From: Pendry, Glenn [REDACTED]
Sent: 01 December 2020 08:38
To: Anita Gardner <Anita.Gardner@arun.gov.uk>
Cc: 'Lynnette St quintin' [REDACTED]
Subject: AB/63/20/DOC 74-76 Canada Road, Arundel, West Sussex BN18 9HY - Planning Extension of Time

Condition 4 – Construction Plant and Materials

Condition 8 - Access

- Indicates Site Cabin - Oasis Unit Location
- Indicates Proposed Materials offloading Area to Storage Area/s.
- Indicates Proposed Materials Storage Area
- Indicates Proposed Contractor Parking Provision (on-street)

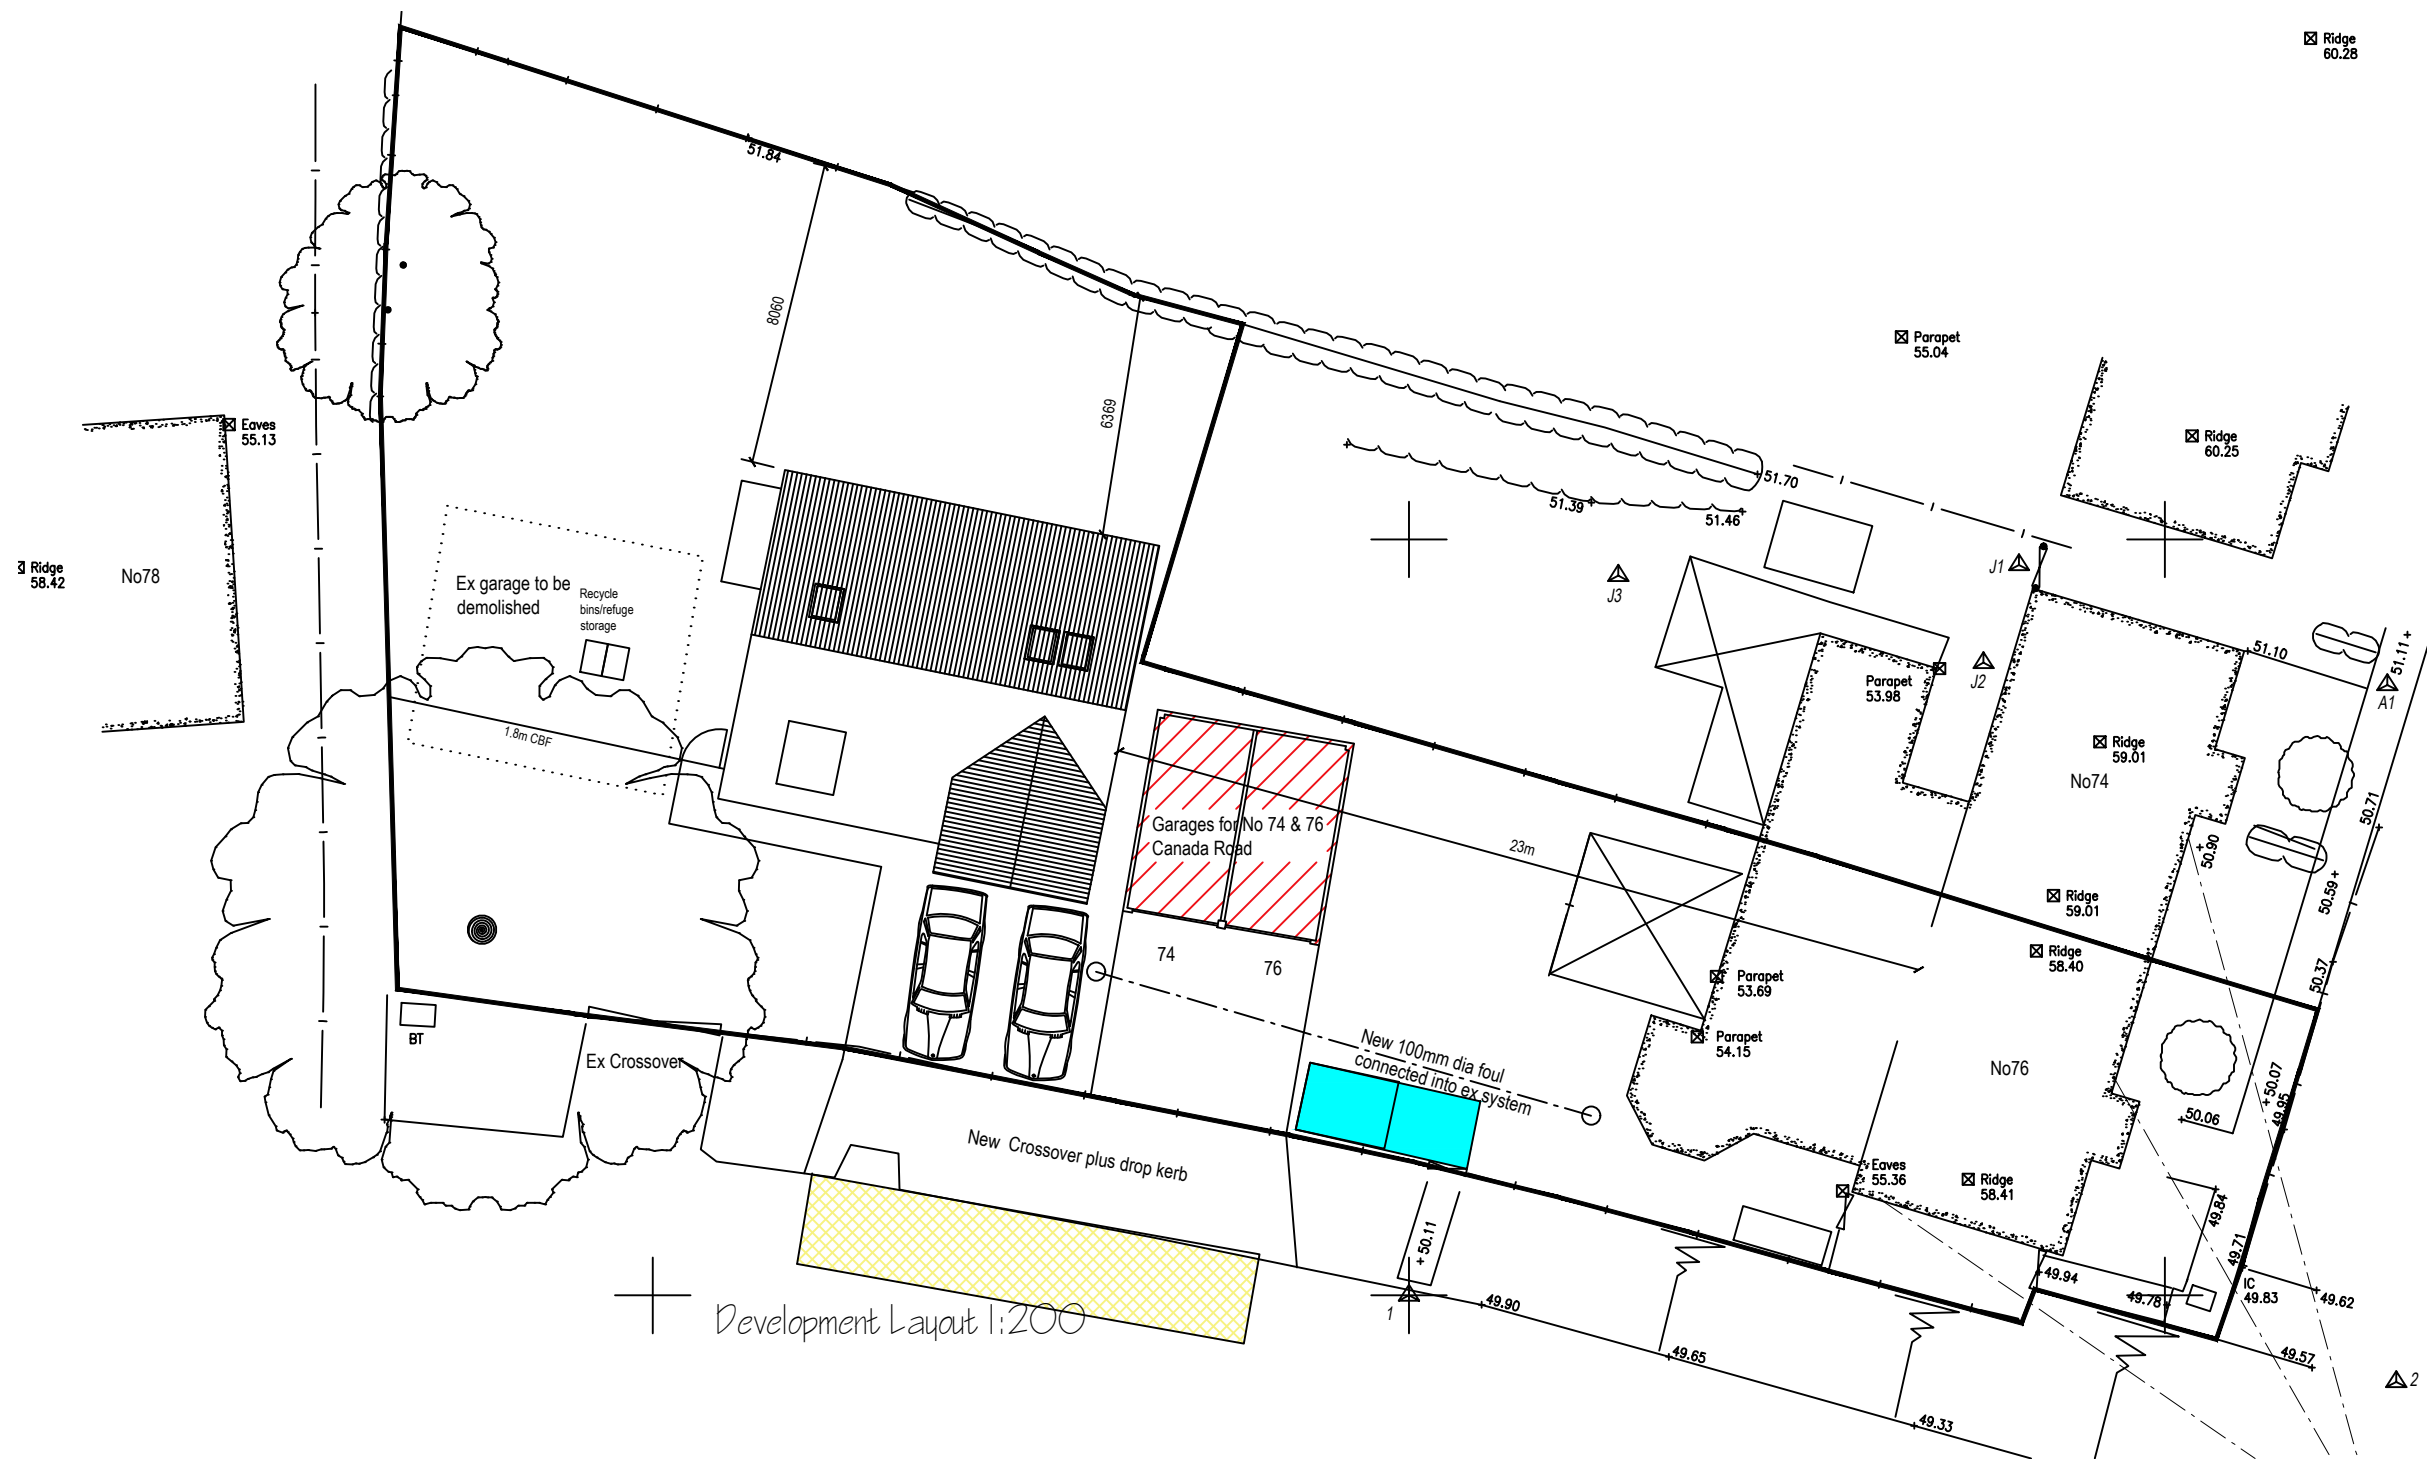
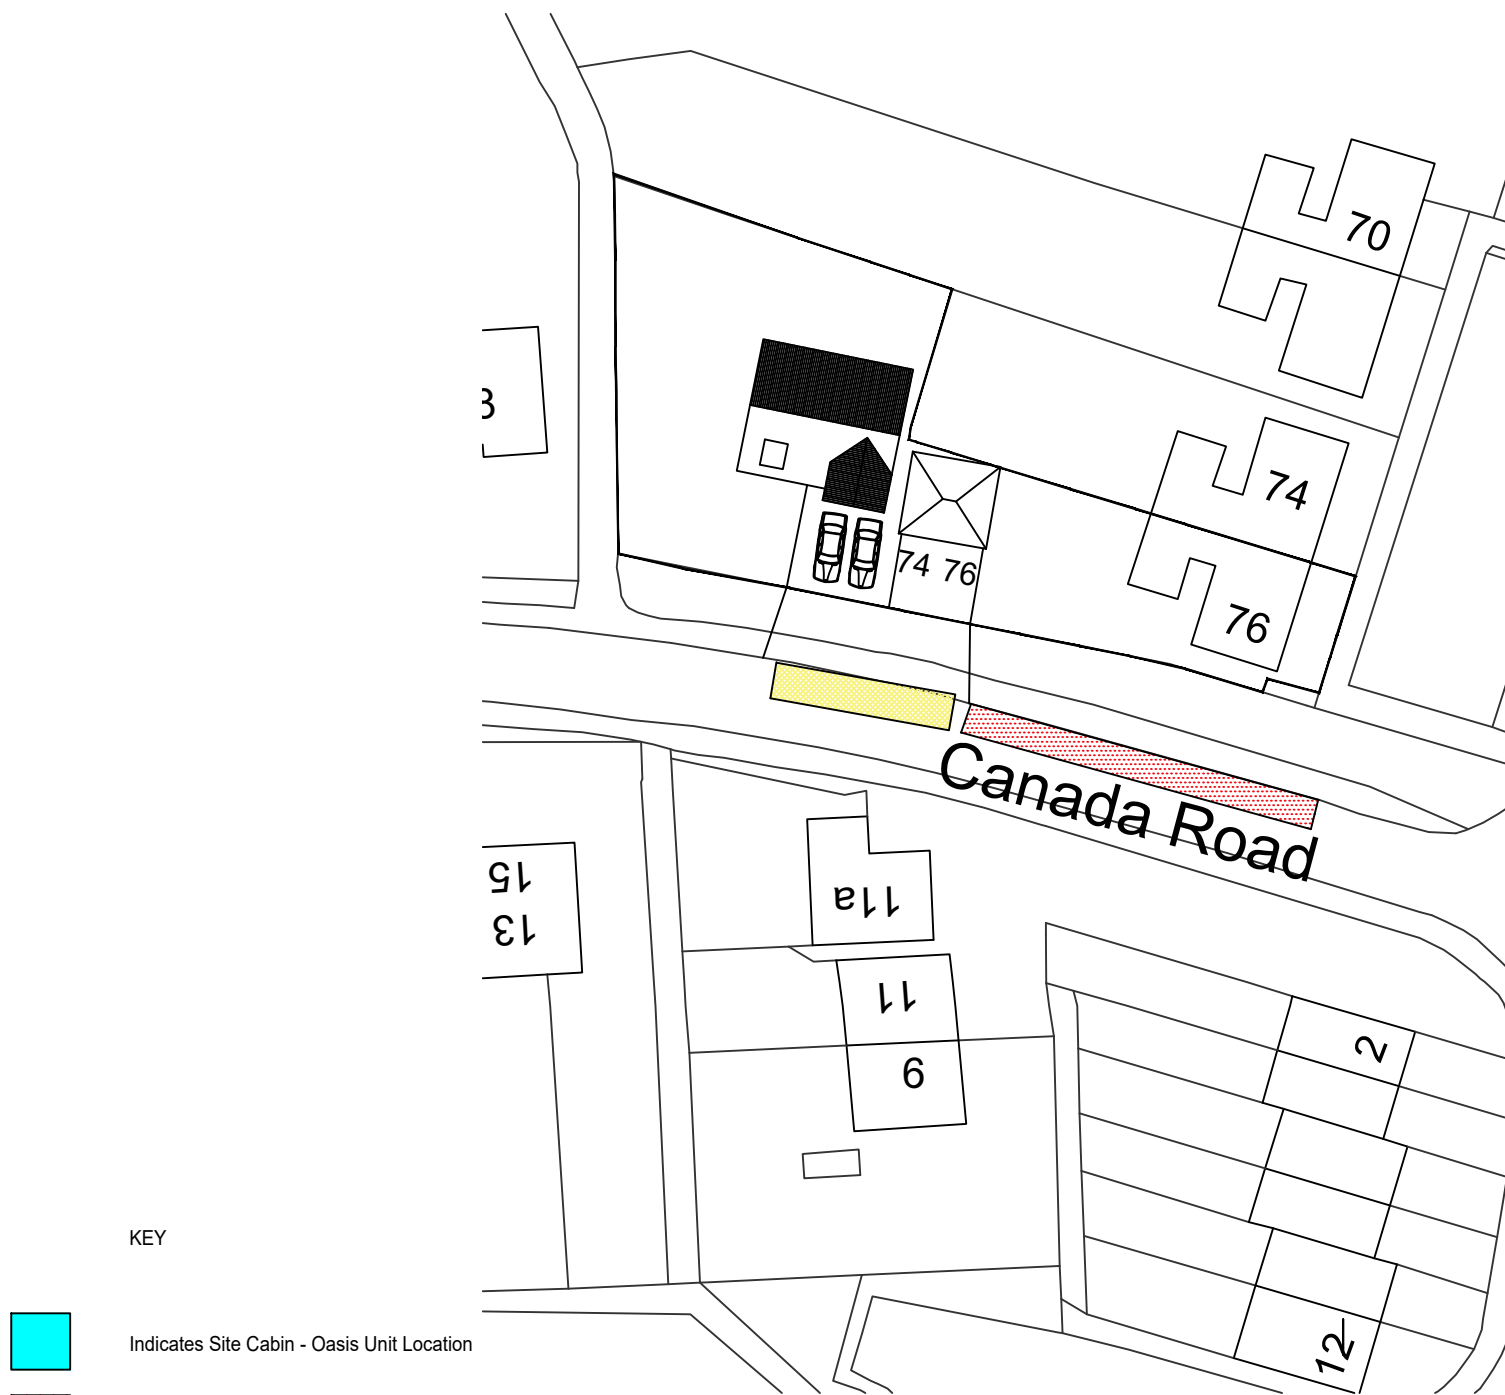
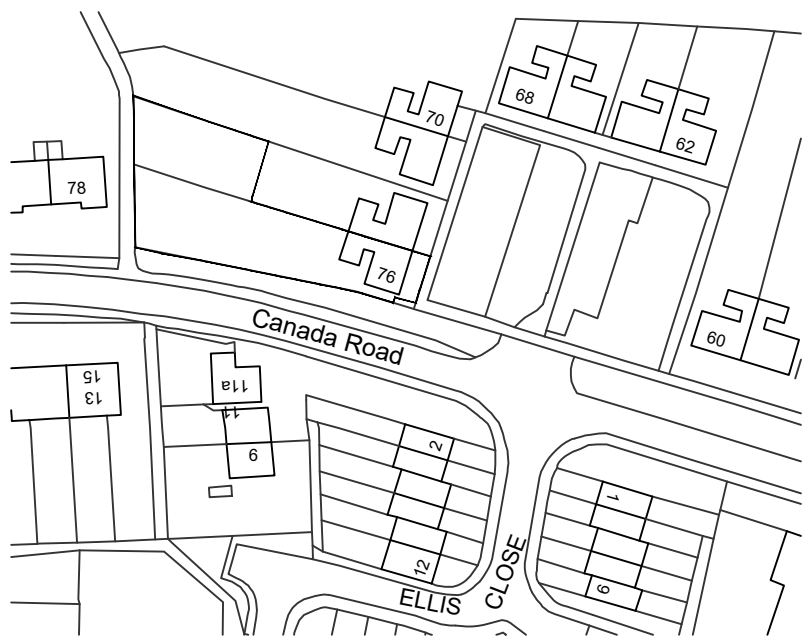
As per, and adding to Stephens comments 30th July WSCC. Parking by contractors can naturally take place on street while taking into consideration any existing traffic regulation orders. However it is not advised that a specific area for this is marked on discharge of condition plan. This is because the roads status as public highway is secured by statute and thus should be free for use by all. It would also restrict contractors to only parking in those specific locations when they may not be free.

This could be mitigated by way of a temporary traffic regulation order, but the applicant does not seem to be proposing this.

It would be better if a statement was made similar to “Due to the constraints of the site contractors will be required to park on street in a safe and considerate location. Any such parking must take into consideration any existing traffic regulation orders.

Similarly with materials storage, typically we try and avoid this if possible but it can be permitted with the appropriate licence agreement from WSCC Highways. Please can the applicant confirm if they do wish to store materials on the highway and I will enquire with the area office if ‘in principle’ such a licence would be forthcoming in such a location.
